Application number: 2019/91327	
What is the application for?:	Reserved matters application pursuant to outline permission 2017/90207 for erect
Address of the site or building:	Thongsbridge Mills, Miry Lane, Thongsbridge, Holmfirth, HD9 7RW
Postcode:	HD9 7RW

Type of comment: An objection
Firstly, we would wish to point out that we have no objection in principle to the development of this site for employment uses. However, we wish to strongly object to the current Reserved Matters planning application 2019/91327 on the following grounds - In terms of Local Plan Policy LP24, the form, scale, and layout of the development does not respect nor enhance the character of nearby heritage assets and the landscape in general because it appears that the site is over-developed. Because of their size and layout, the proposed buildings are far too close to nearby residential properties. One of the proposed buildings is two storey in height and is only 5 meters away from the site boundary (which is low stone wall) The proposed building nearest my property will have a significant adverse impact on our residential amenity due to the fact that the scale of the unit will be be overbearing because of

8_Access Road Elevation 1: 200

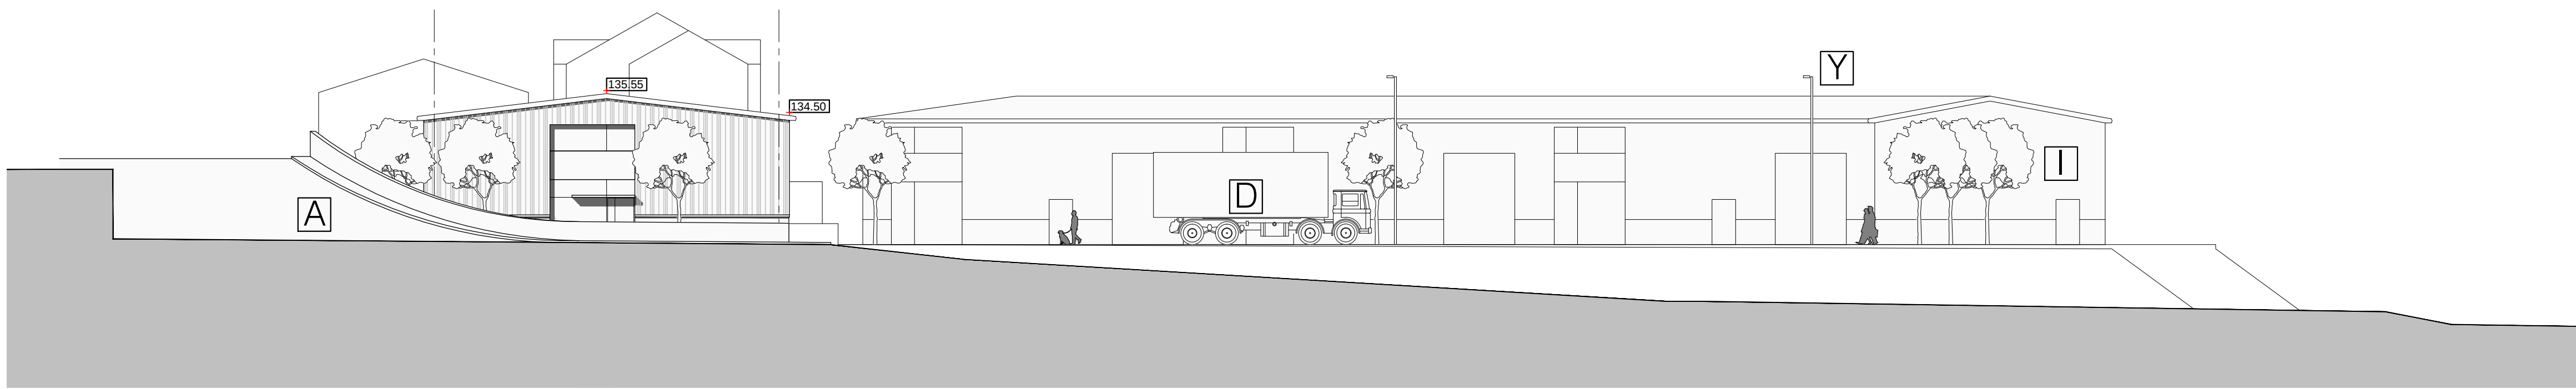
as it makes reference to the substation but this in fact is attached to the rear of Mill Millfields House

Given the above, we would therefore request that the Council seeks amendments to the proposed building (Scale, Appearance, and Layout in the Reserved Matters application) which would have less impact on our property and our residential amenity and which would accord with the previous report to Planning Committee. In terms of
